PENDLETON PARISH COUNCIL

Planning application 3/2015/0658 re Proposed demolition of existing house and outbuildings and replacement house and garages at White Lodge Main St Pendleton BB7 1PT

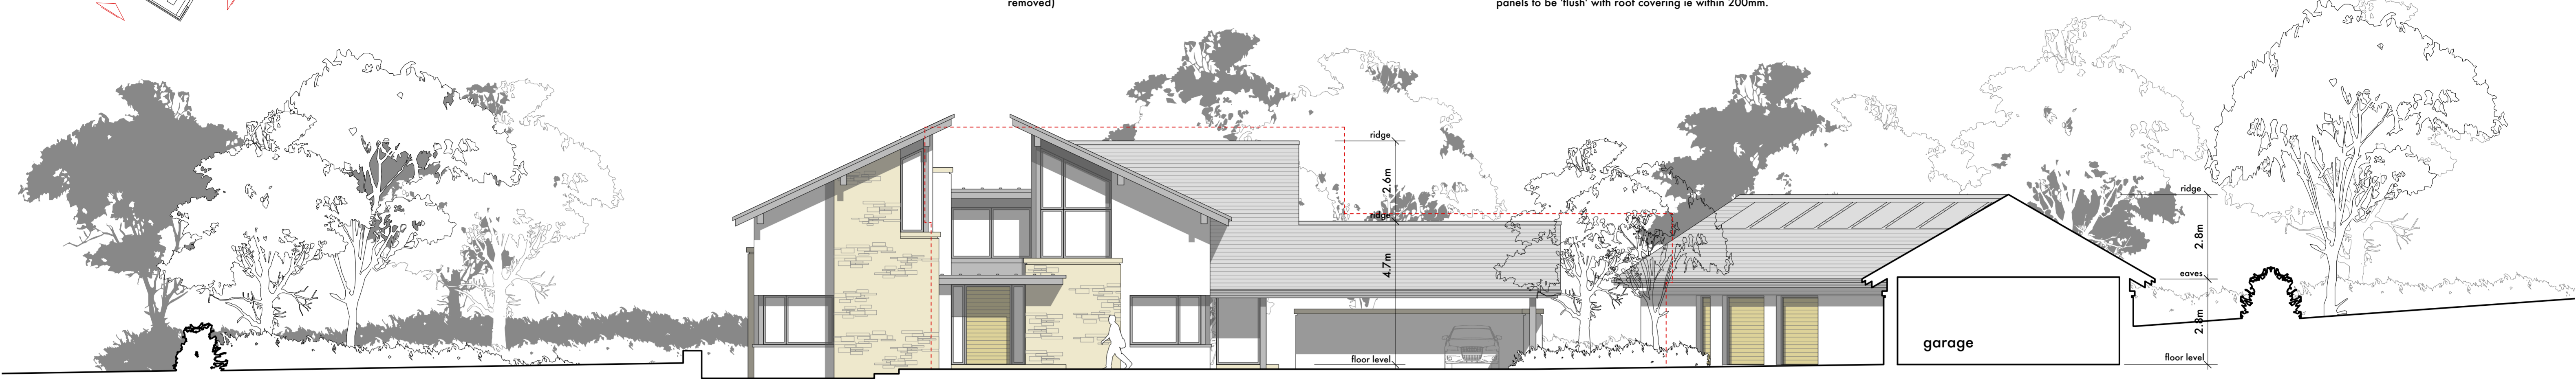
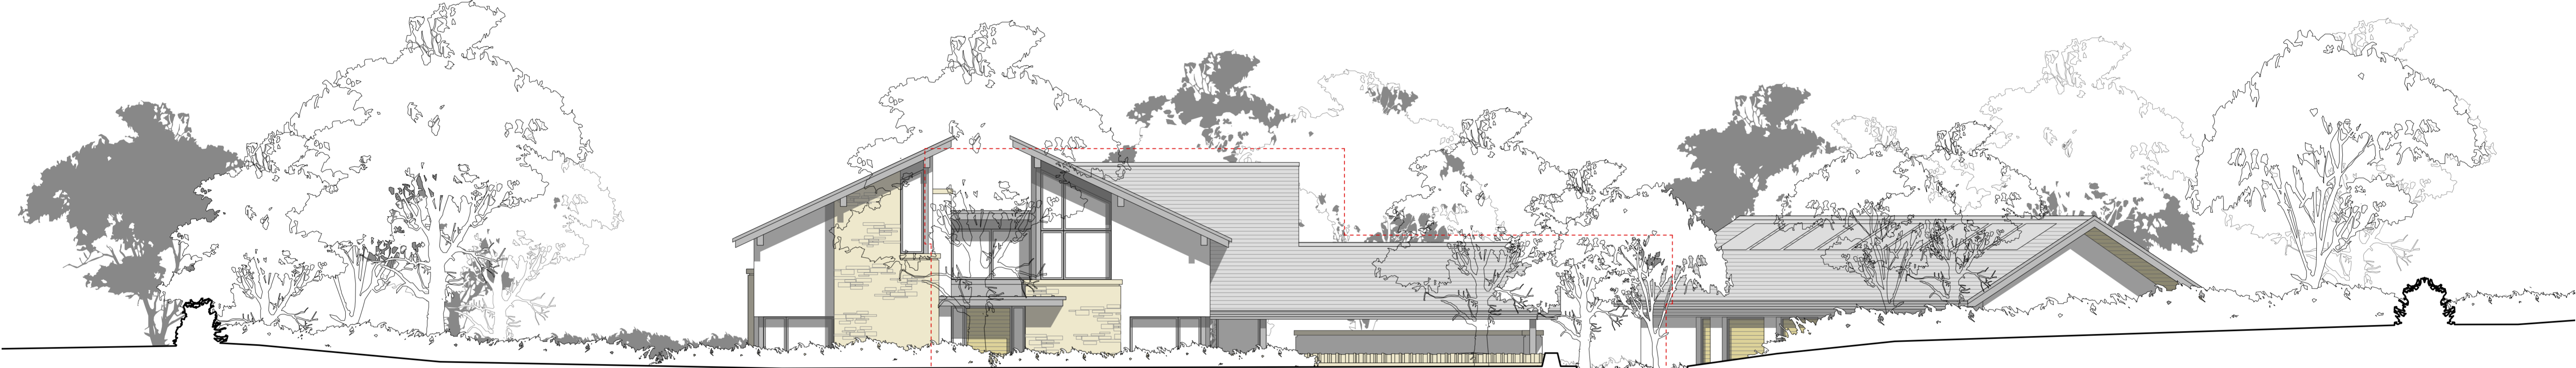
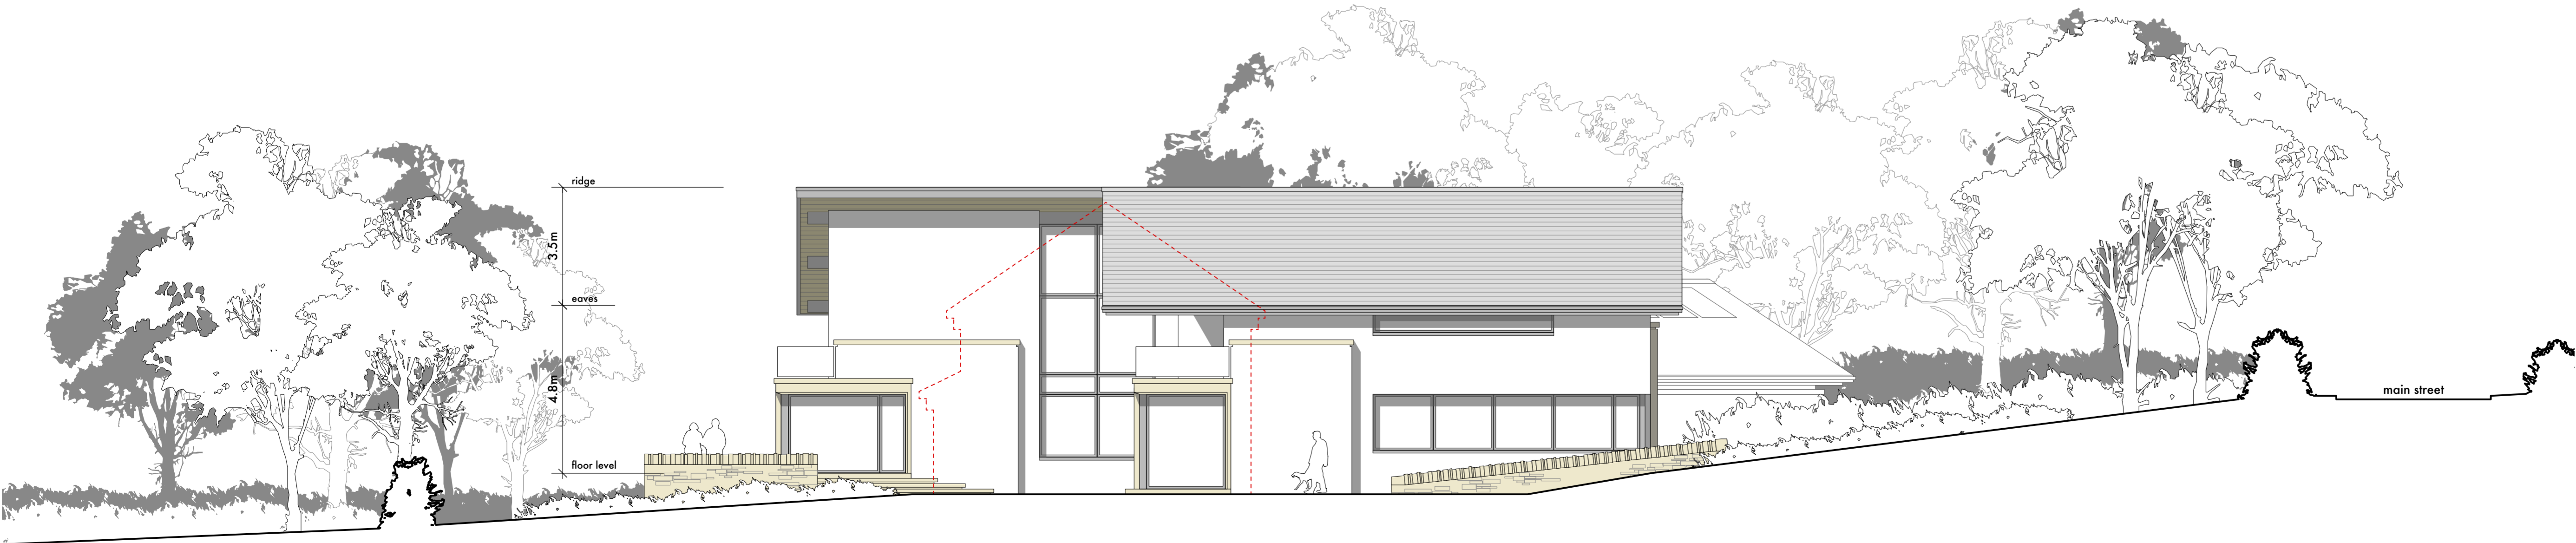
There are no objections to this application but Councillors made two requests- Firstly that the demolition and construction vehicles approach the site from Sabden Road and NOT through the narrow village road and secondly that the stone on the front of the buildings be real stone and not manufactured stone.
